STATE OF NORTH CAROLINA  
DEPARTMENT OF TRANSPORTATION

August 31, 2020

Subject: **Revised Modification Request for Section 404 Individual Permit, Section 401 Water Quality Certification and Neuse Riparian Buffer Authorization** for Interstate 40 Widening and Improvements from I-440/US 64 (Exit 301) to just north of SR 1525 (Cornwallis Road), including improvements to NC 42 and SR 1010 (Cleveland Road) in Wake and Johnston Counties, Federal Aid Project No. IMNHF-040-4(139)301; TIP Numbers I-5111 and I-4739, Division 5. Debit \$570 from WBS Element 42346.3.1.

PROJECT REFERENCE NO.	SHEET NO.
1-5111/1-4739	42
R/W SHEET NO.	
ROADWAY DESIGN ENGINEER	HYDRAULICS ENGINEER
DOCUMENT NOT CONSIDERED FINAL UNLESS ALL SIGNATURES COMPLETED

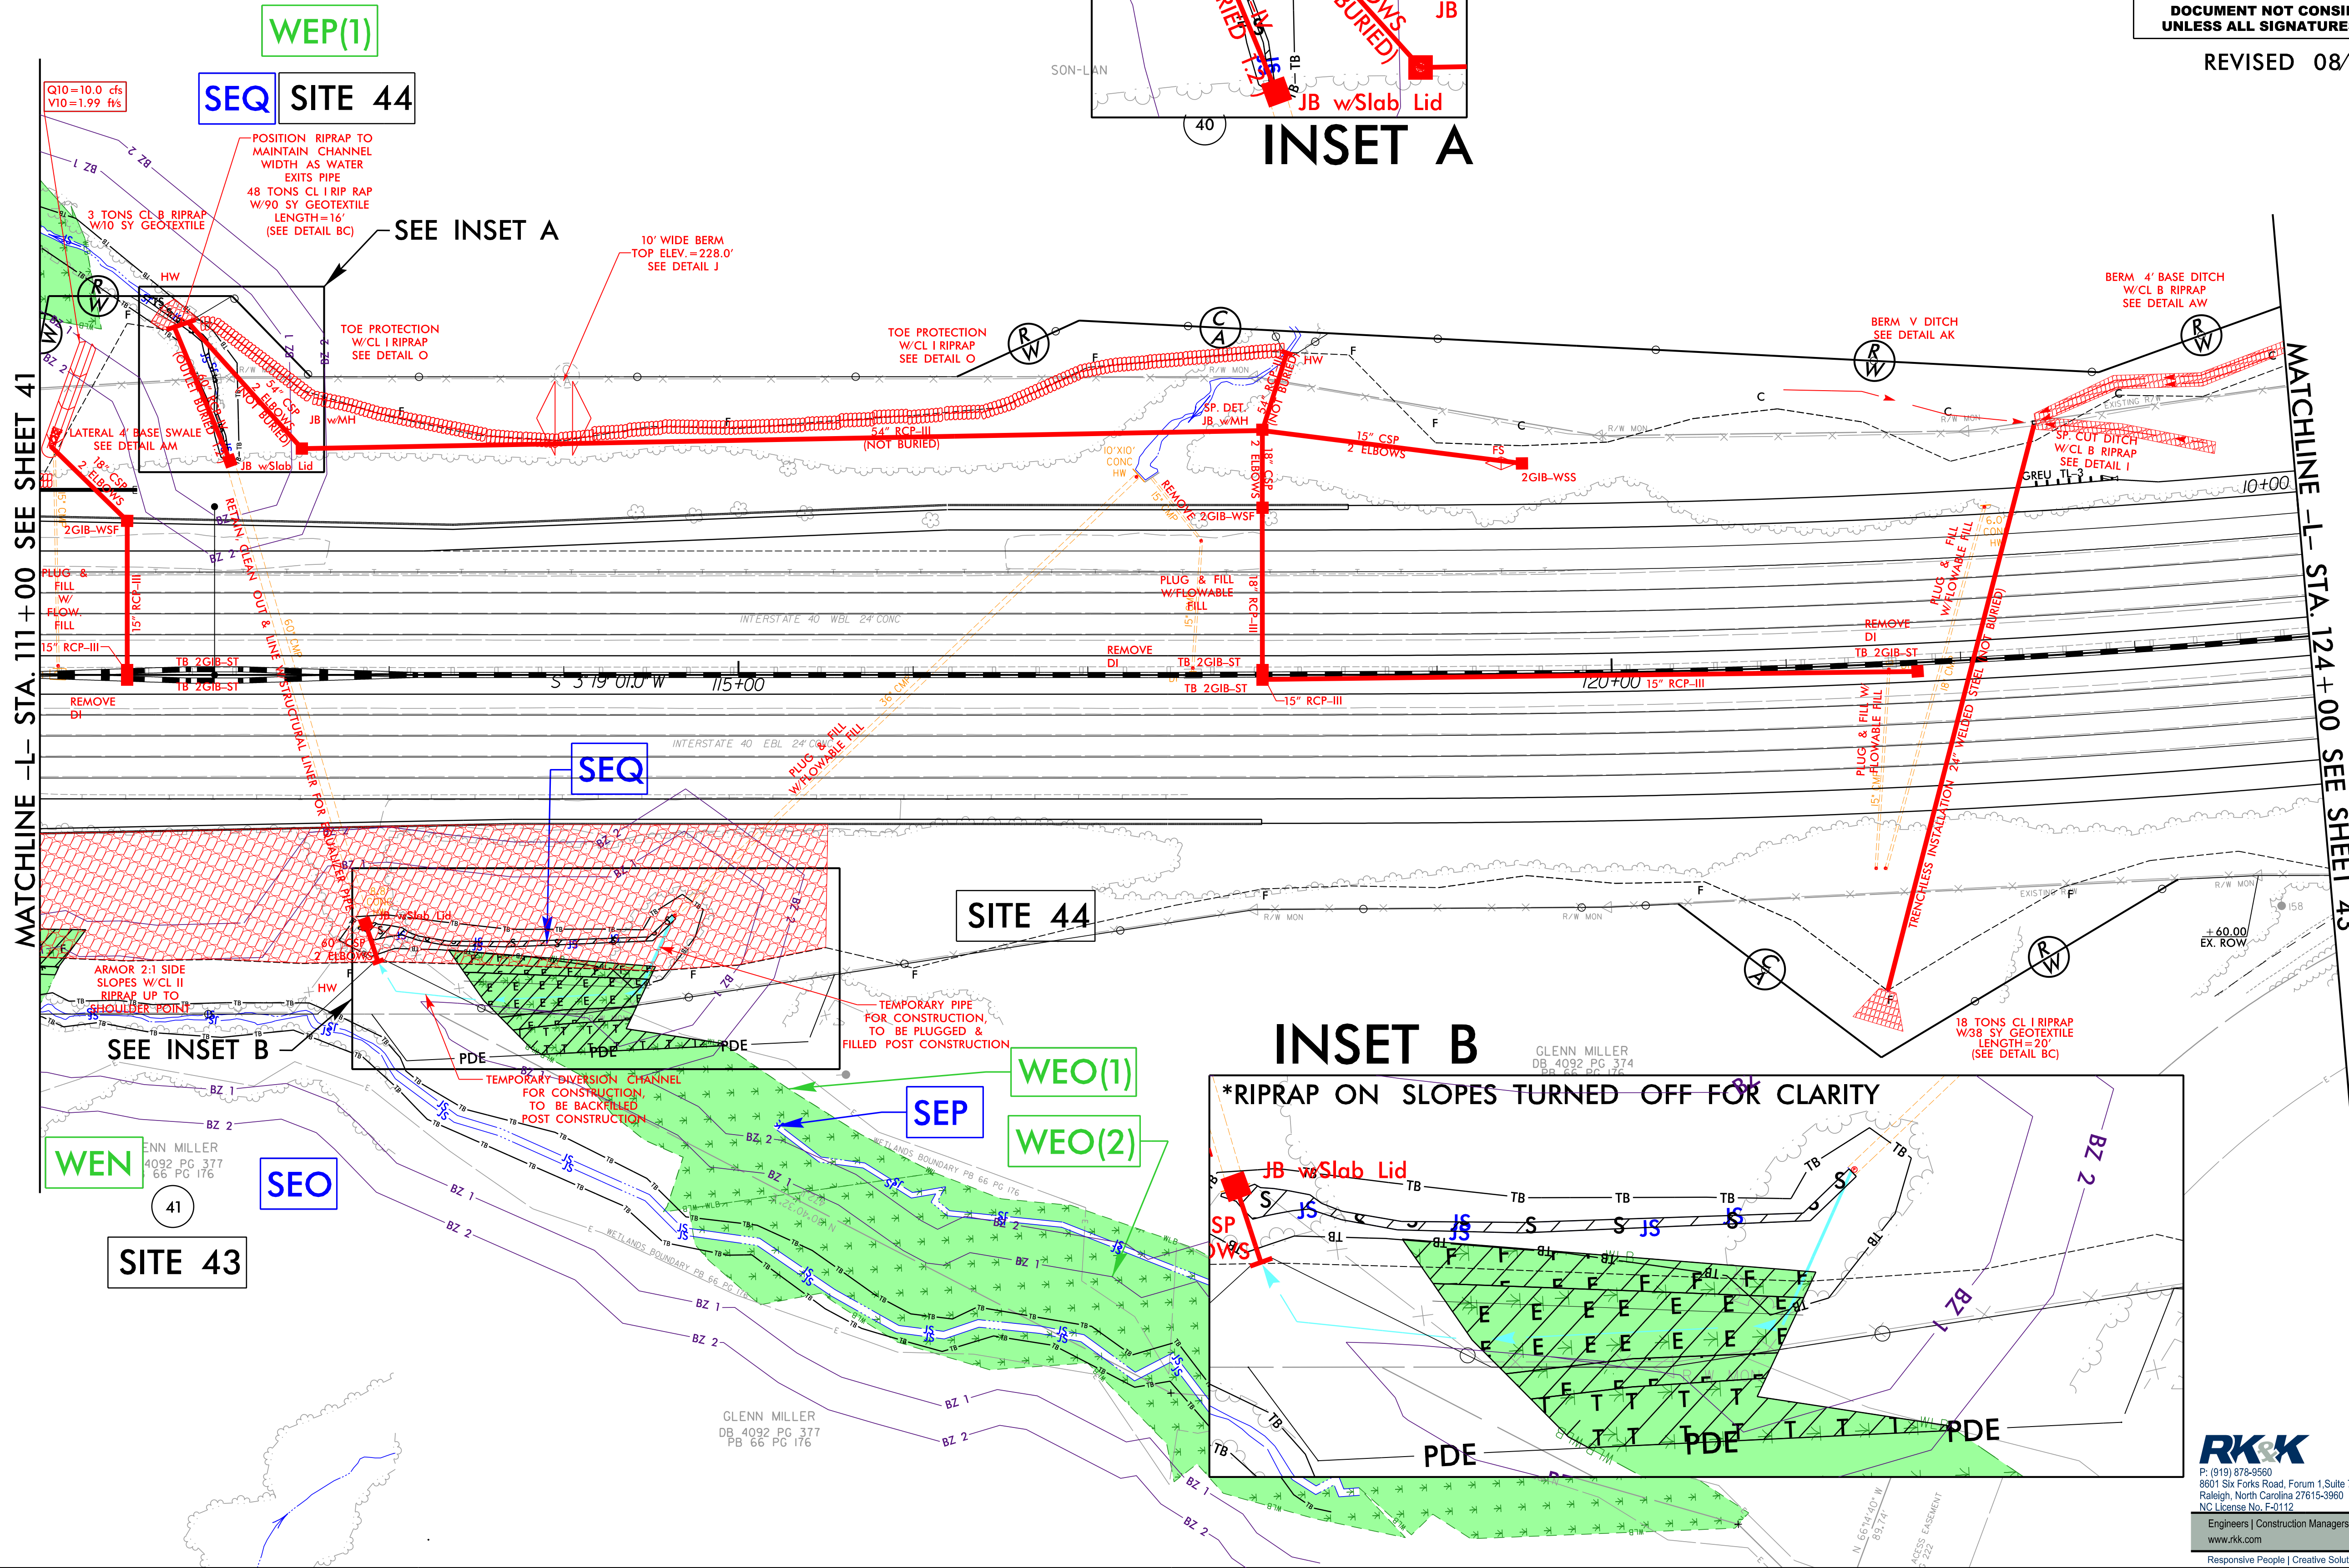
A field revision is being requested at Site 44. Currently, stream SEQ is piped from the east side of I-40 to the west side, travels along the west side of I-40 for approximately 80 feet, then is piped back to the east side. The original design kept this drainage pattern by boring a new 54" steel pipe to the west side of I-40 and then extending the existing 60" pipe to convey SEQ back to the east side. The new design proposes to install a 54" pipe along the east side of I-40 that outlets to the same 60" pipe, thus eliminating the need to bore a new 54" steel pipe. The 60" pipe will still be extended to convey any drainage from the west side to the east as well as to act as an equalization pipe. For construction sequencing, stream SEQ be placed in the relocation channel, as currently authorized, for approximately 3 months. However, this will be a temporary diversion and shown as temporary excavation in wetlands on Permit Drawing Sheet 124. Once the 54" pipe is installed along the east side of I-40, this channel will be backfilled to preexisting elevations, vegetated, and restored as a wetland.

This modification will result in the following:

- 0.043 ac of permanent wetland excavation becoming temporary
- +765 ft<sup>2</sup> of impacts to Buffer Zone 2 through abandoning the channel

PERMIT DRAWING
SHEET 93A OF 125

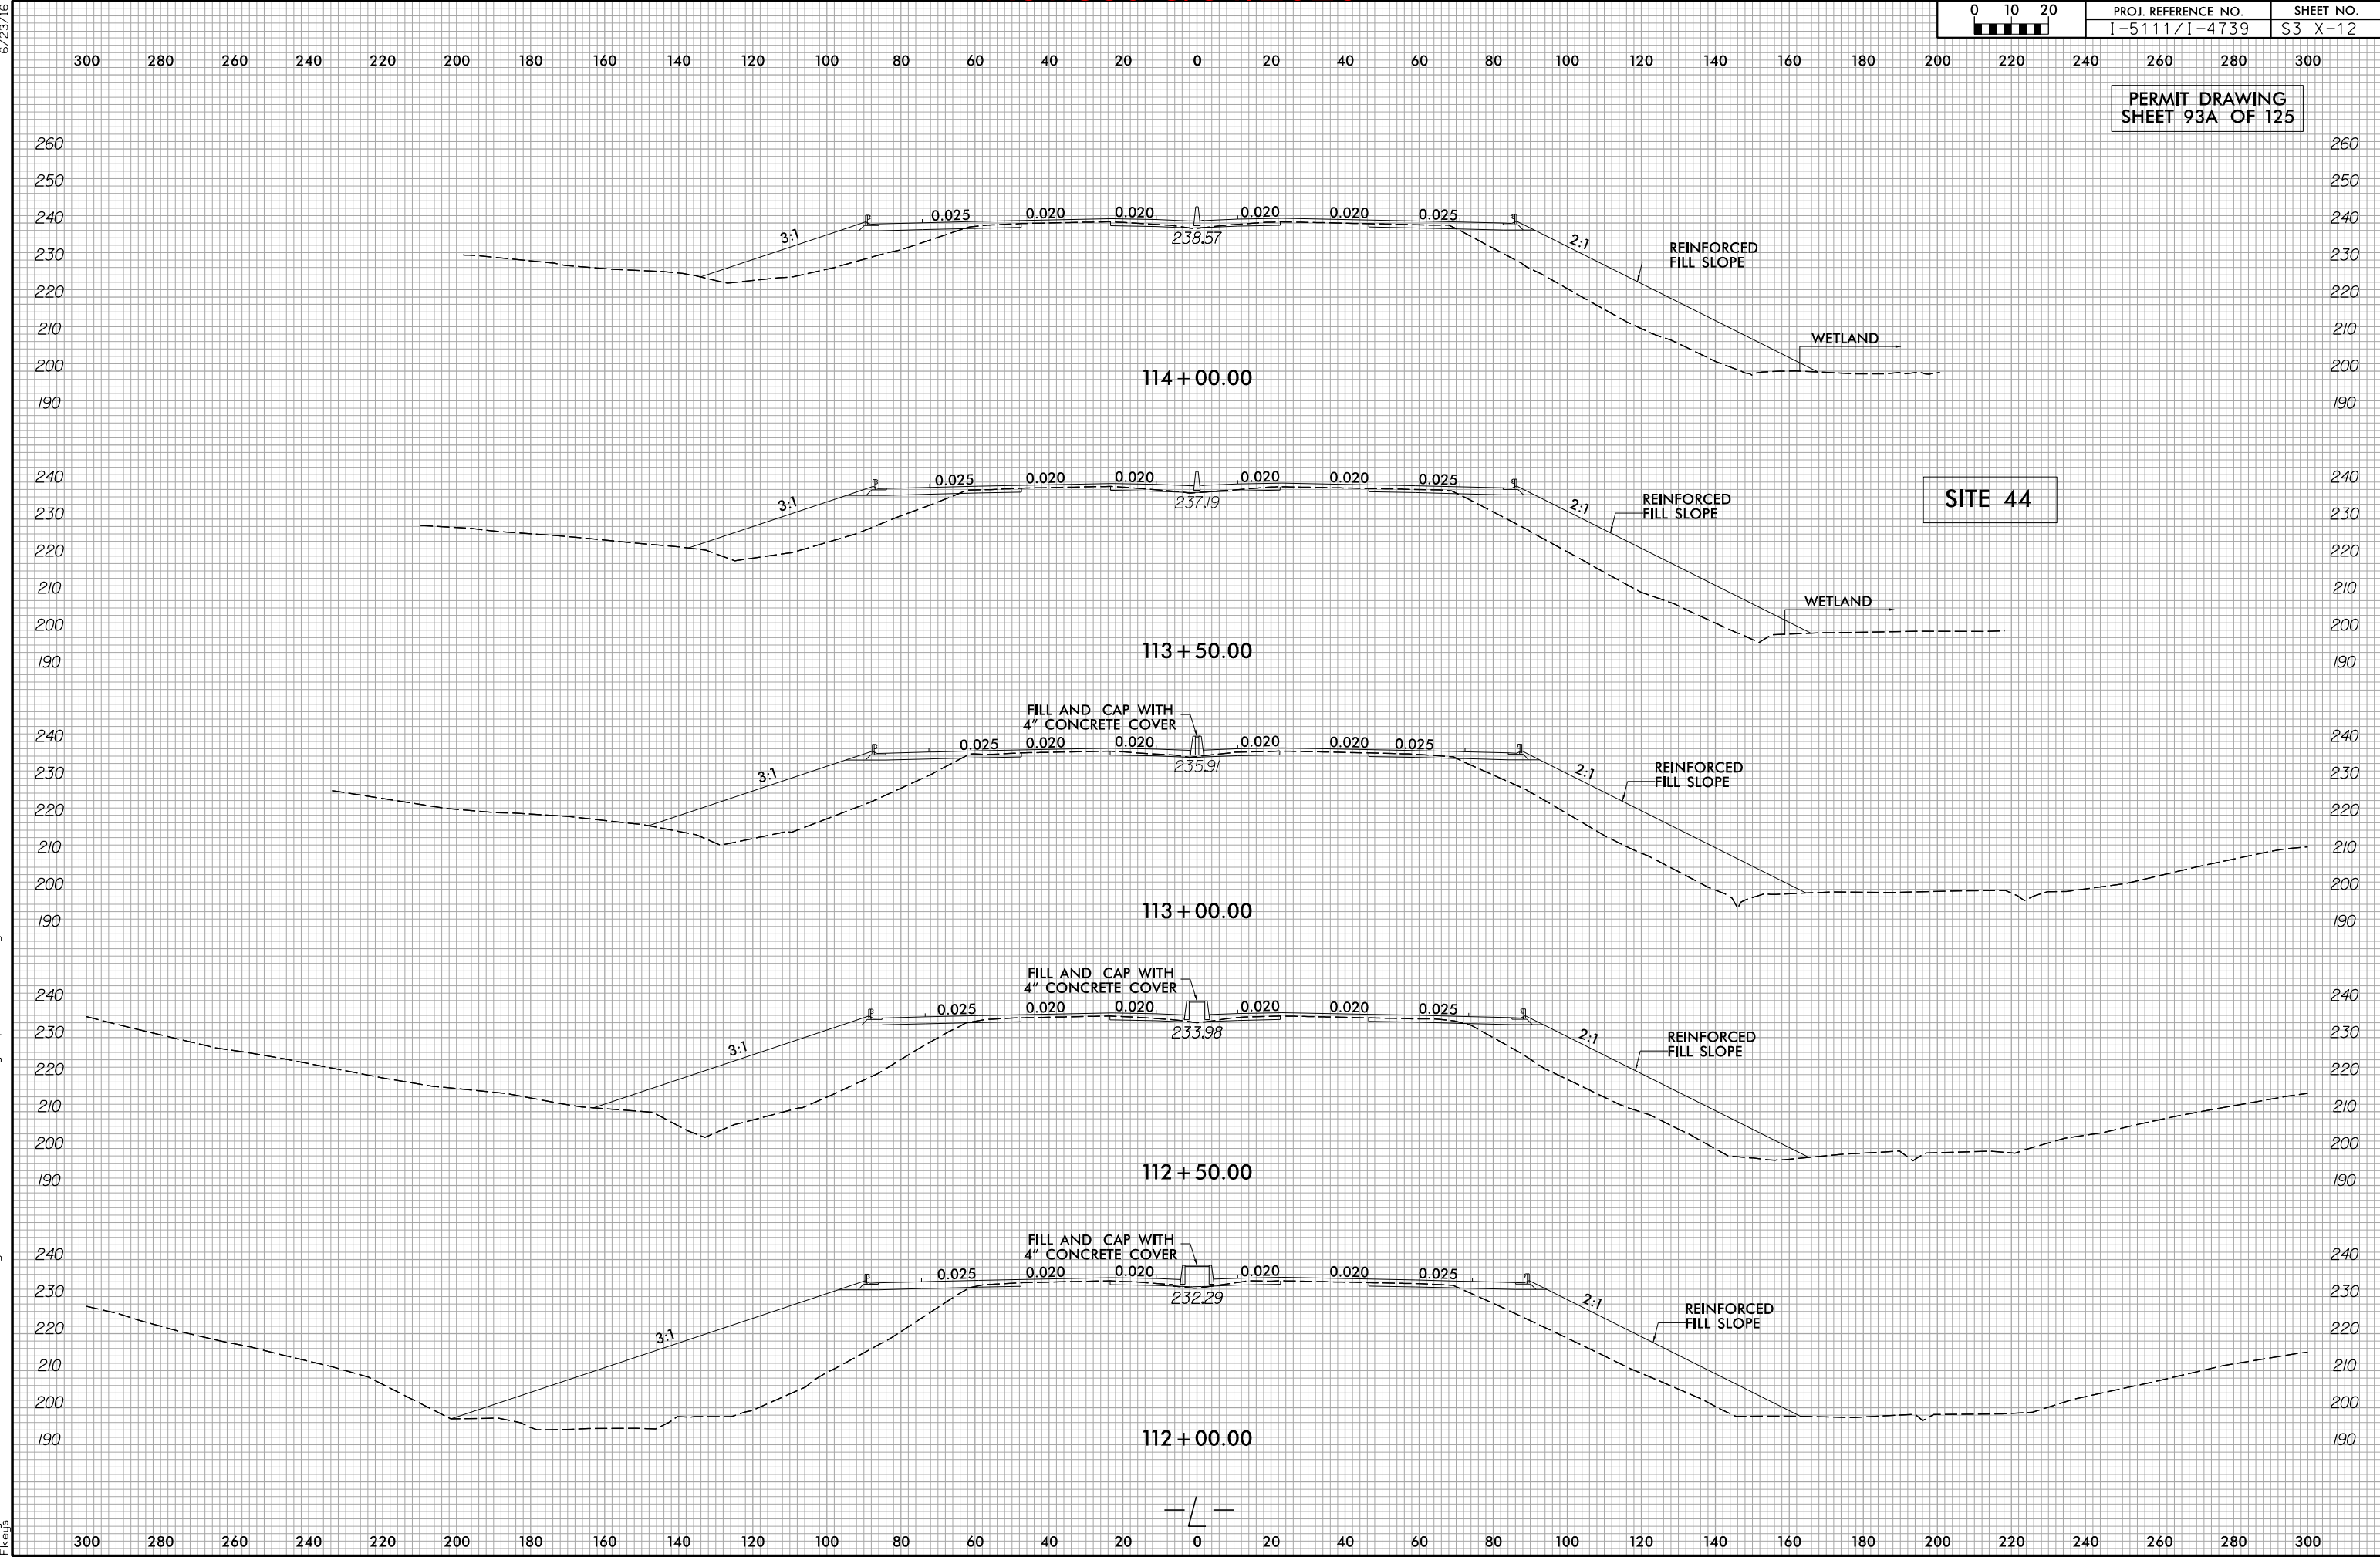
When recalculating the impacts for Site 44, it became apparent that the wetland impacts had been inadvertently under reported in the initial application. These numbers have been corrected on the attached revised impact summary sheets. Permanent wetland fill increases by 0.04 acre to 0.78 acre total. Temporary wetland increases by 0.03 acre to 0.17 acre total. A cross-section of Site 44 (Permit Drawing 93A) is also included as that had been omitted from the initial permit application.
